CITY OF ALBUQUERQUE

December 6, 2016

**RE: West central Plaza Addition
Conceptual Drainage and Grading Plan
Engineer's Stamp Date 3-28-2016 (File: K12D015B)**

| SHEET TITLE DRAINAGE MANAGEMENT PLAN | | DATE 3/28/2016 | |

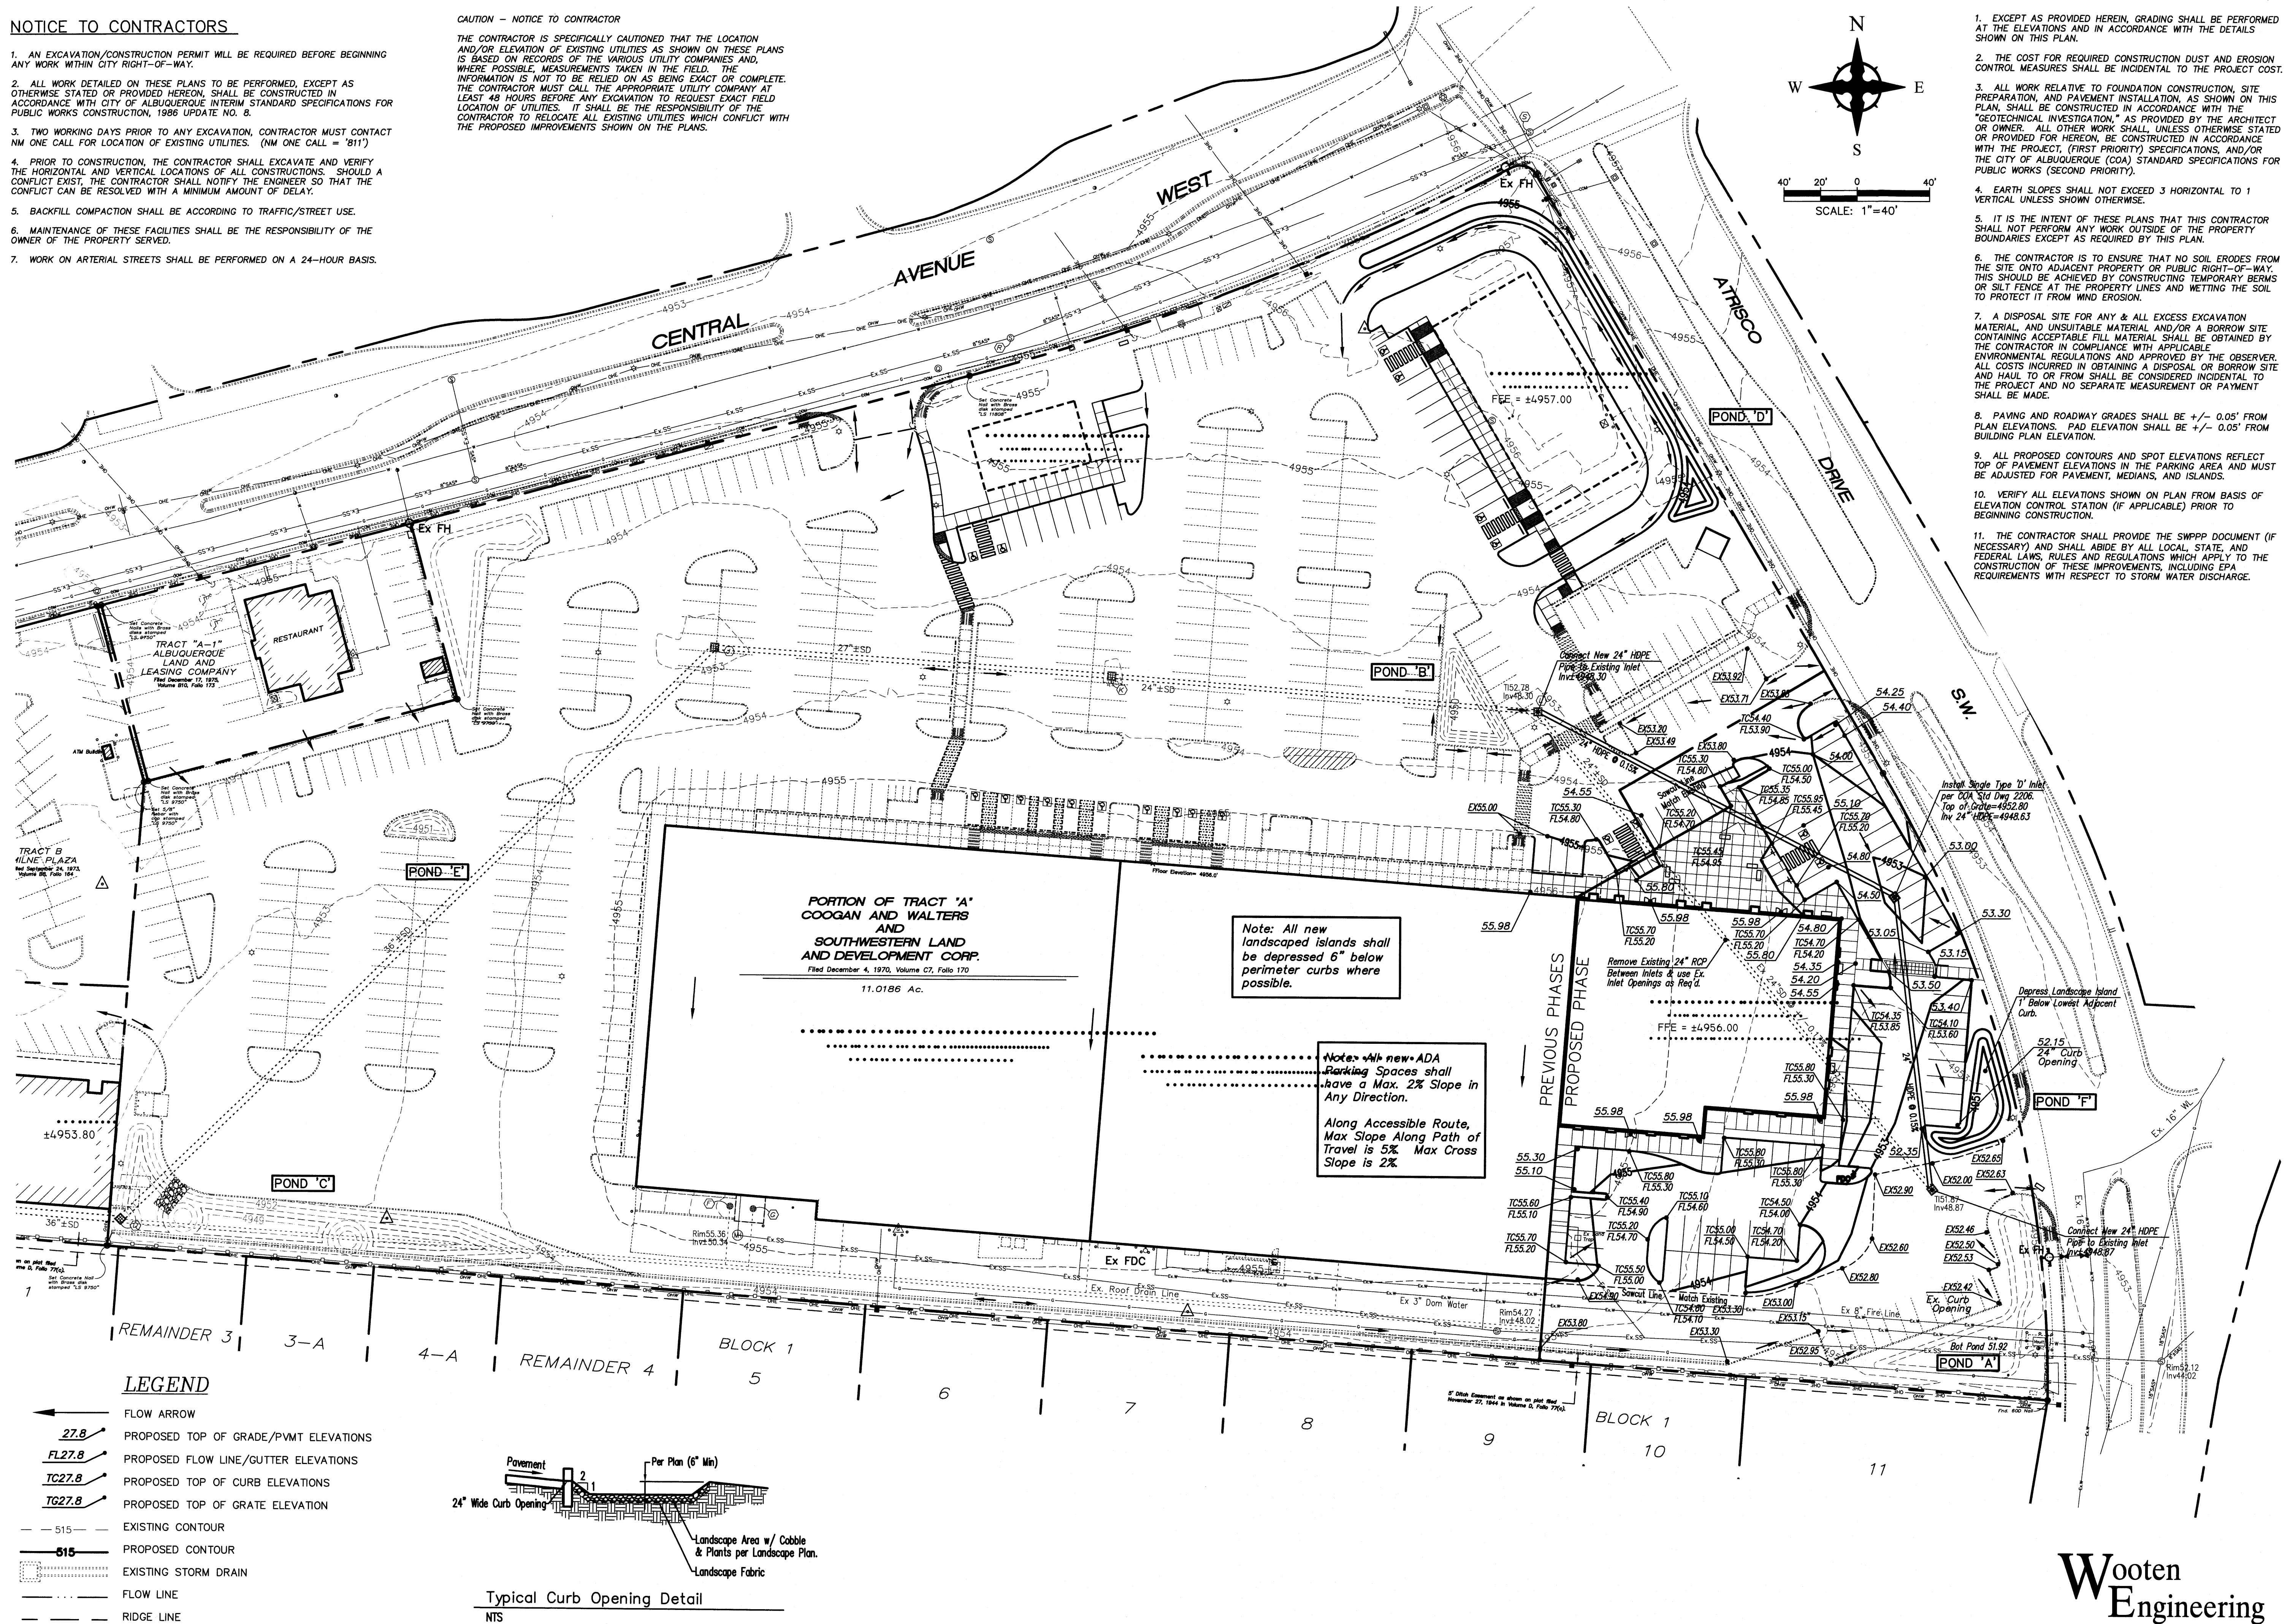
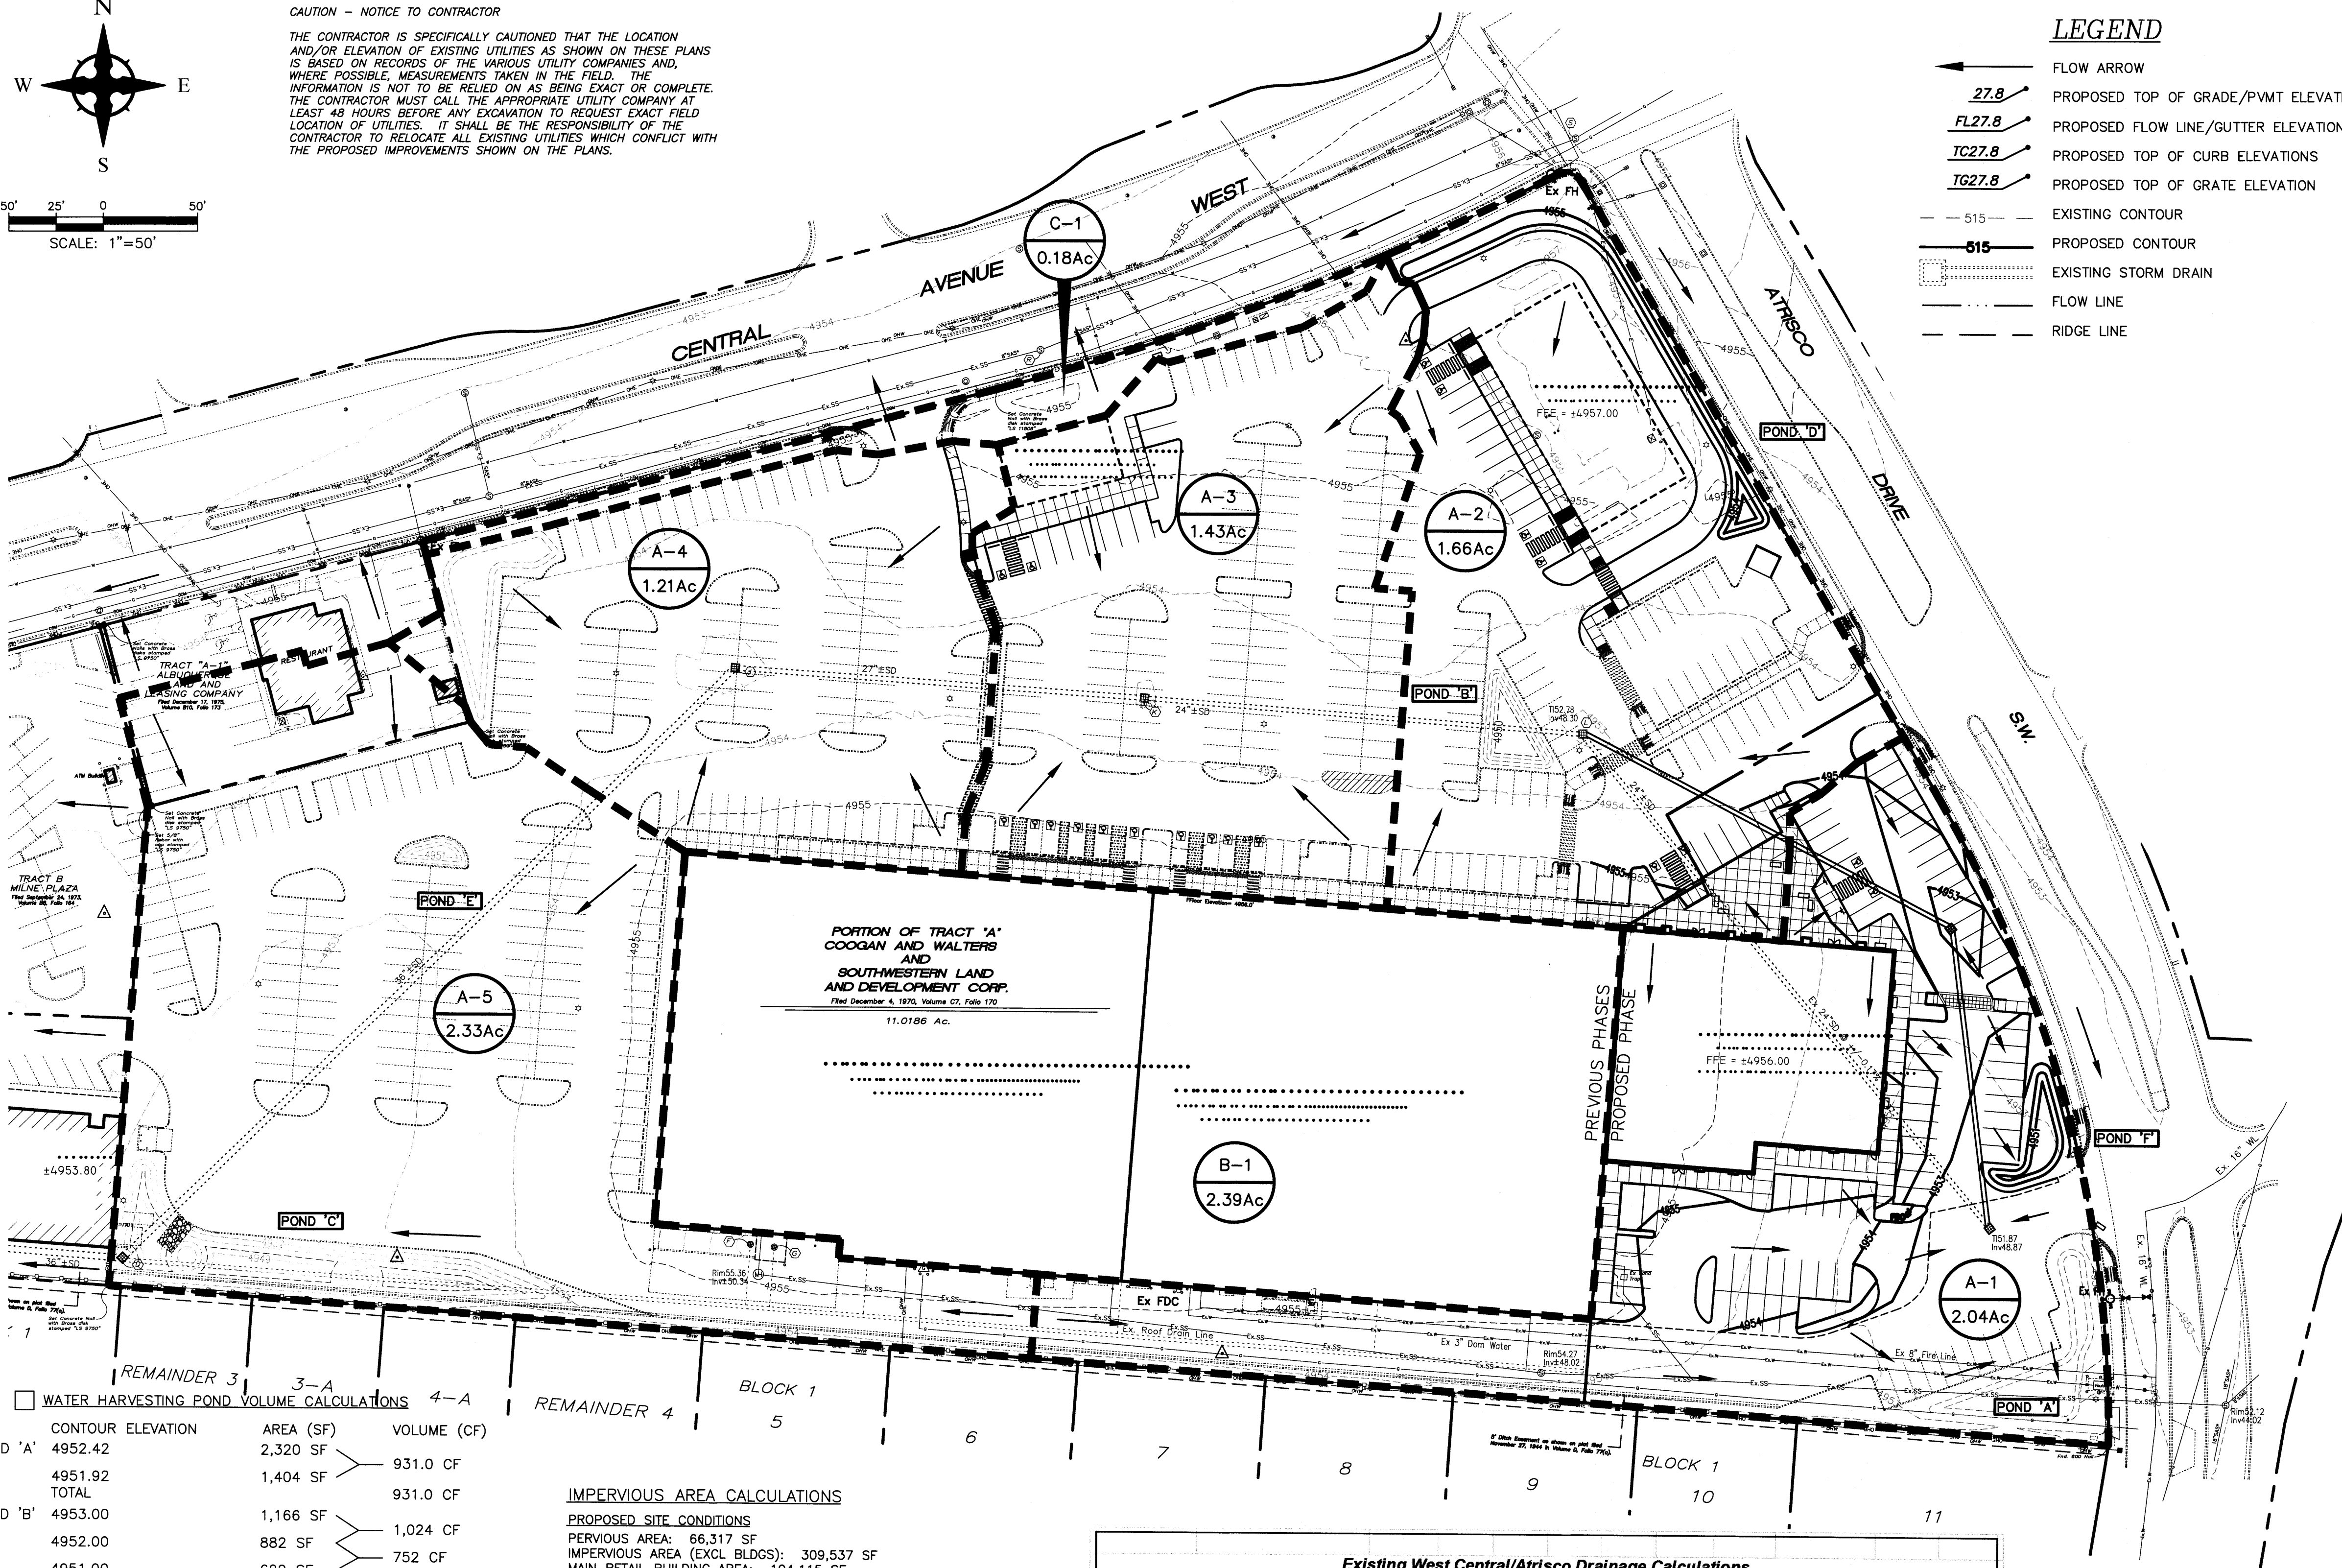
On the certification, please ensure that the land treatment distribution for the proposed condition is correct.

For example basin B-1 is assumed to be 13.4% C and 86.4% D, but it should be 100% D .
The minor discrepancy does not appear to affect the sizing of the facilities, however.
